AGENDA ITEM NO.ARUN DISTRICT COUNCILDEVELOPMENT CONTROL COMMITTEE – 21st MAY 2008Report of the Meeting of the Development Control Post-Committee
Site Inspection Panel held on 6th May 2008

Application - R/46/08 – Demolition of existing bungalow and erection of 3 No. dwellings
22 Mill Lane, Rustington

ARUN DISTRICT COUNCIL		
No.	R	46 08
SUBSTITUTION		
RECEIVED	20.2.08.

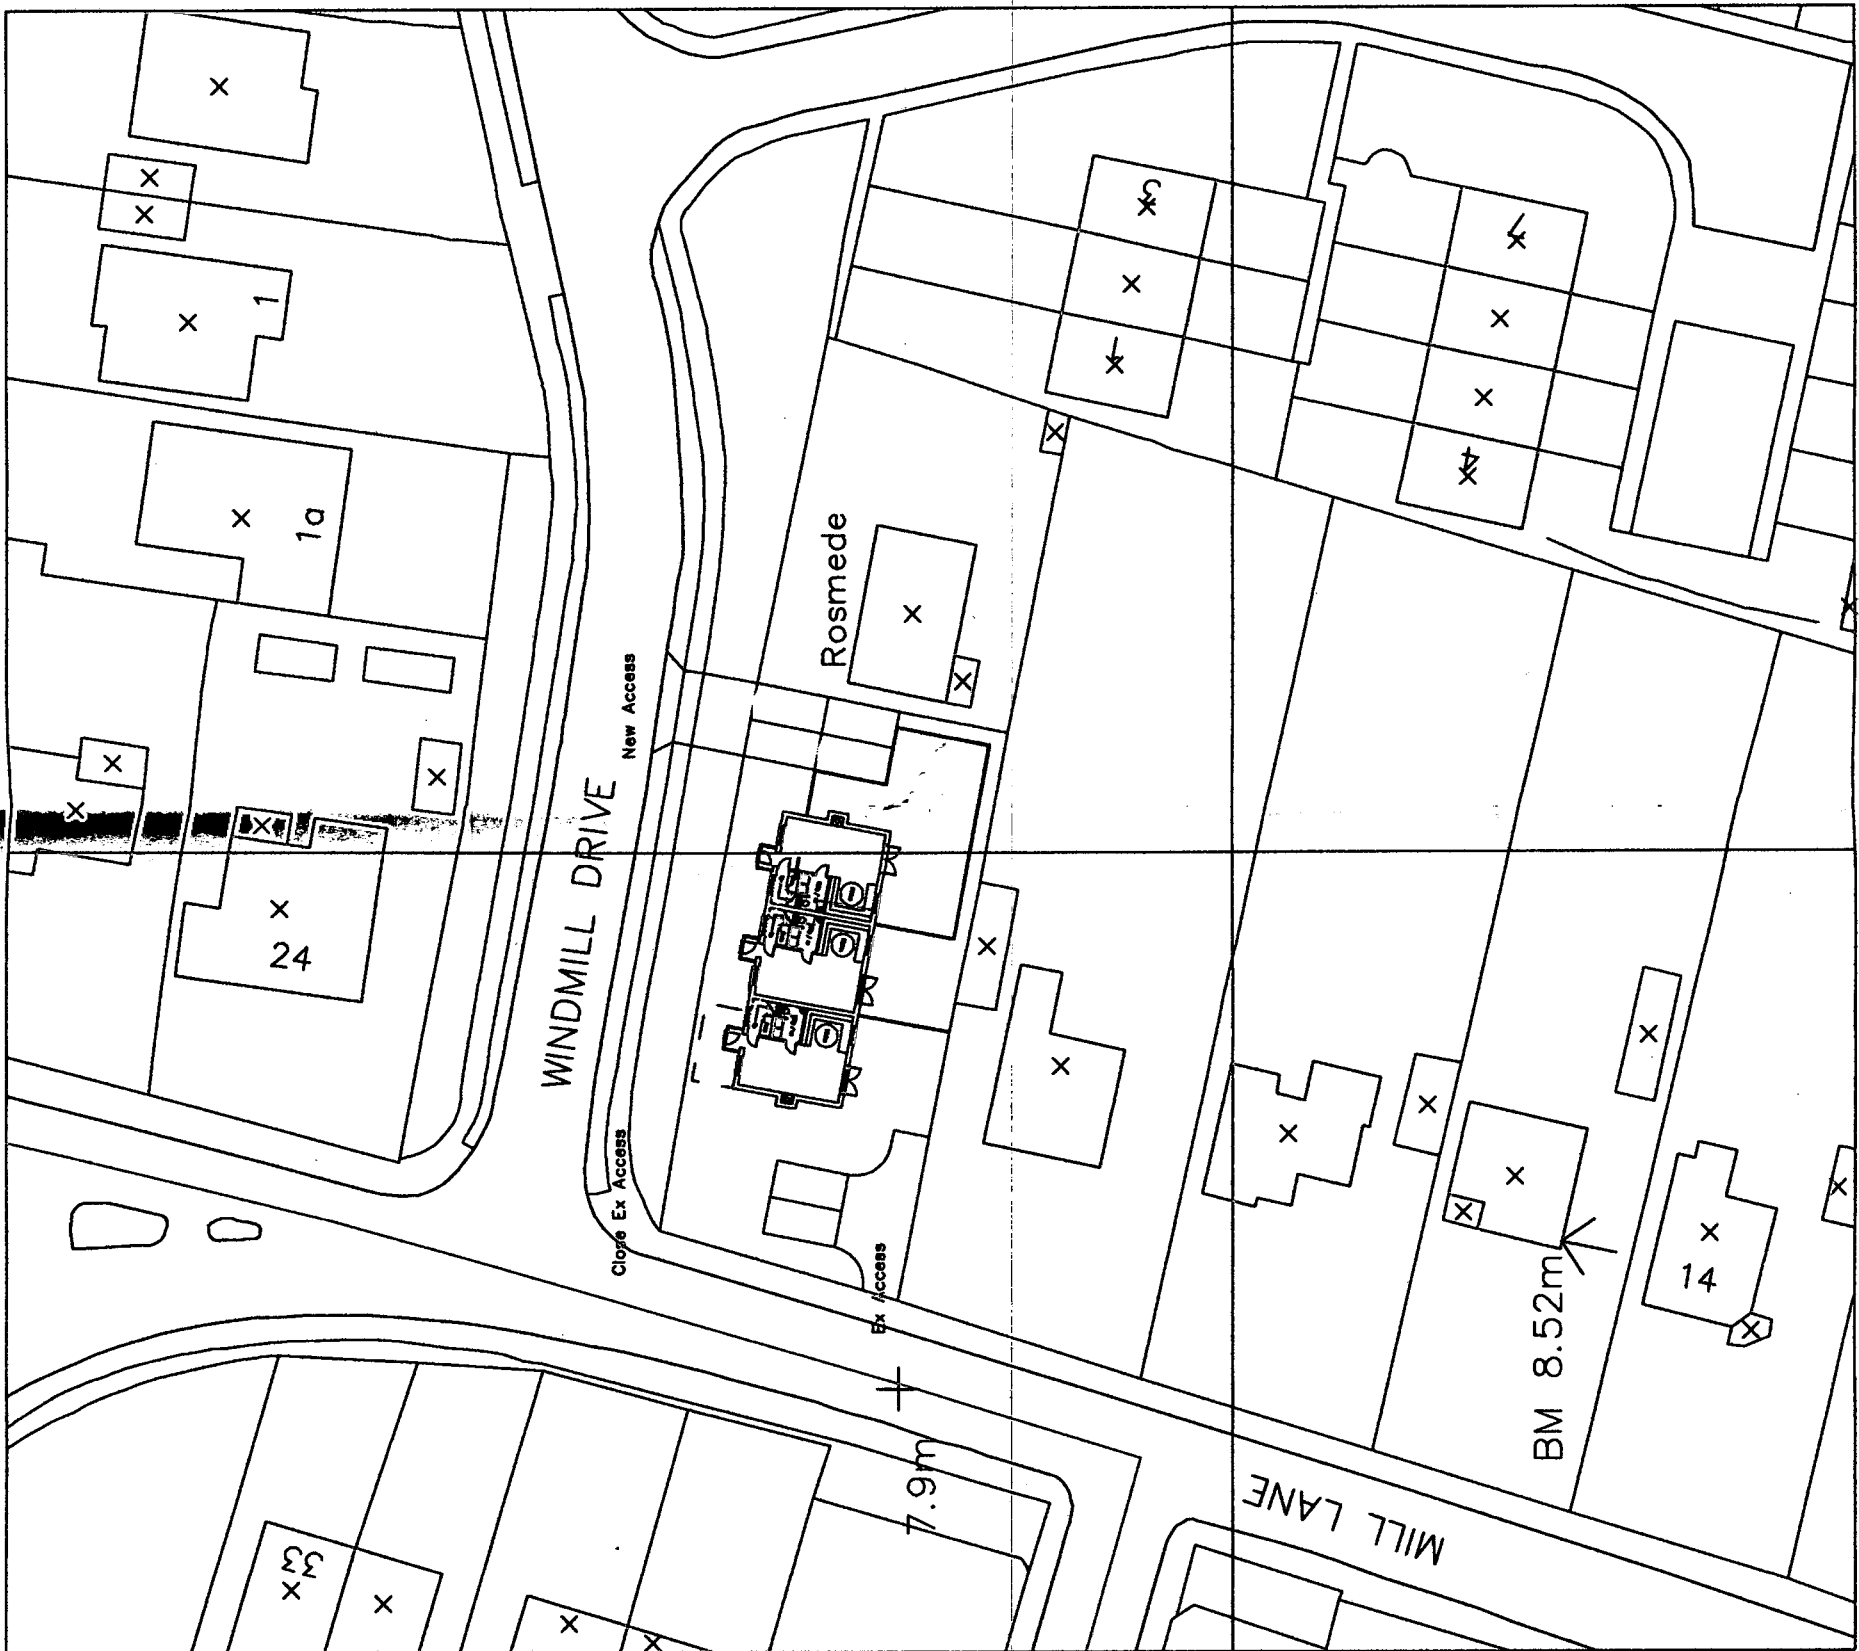
Application No :	R/46/08/
Agenda Page No :	11-18
Reason for the Update ▪ Substitute Plans The agent has submitted an amended block plan, which has re-orientated the proposed dwellings to face Mill Lane. ▪ Letter of Representation Two Third Party Letters of Objection were received in response substitute plans.	
Officer Comment: An amended recommendation sheet is attached. All of the points raised in the third party letters of objection have been addressed in the Officers report.	
Note: Changes to recommendations, conditions and/or reasons for approval will always be accompanied by a new replacement recommendation sheet.

- 8 This permission relates to the plans as submitted and amended by substitute Block Plan dated 02-05-2008.
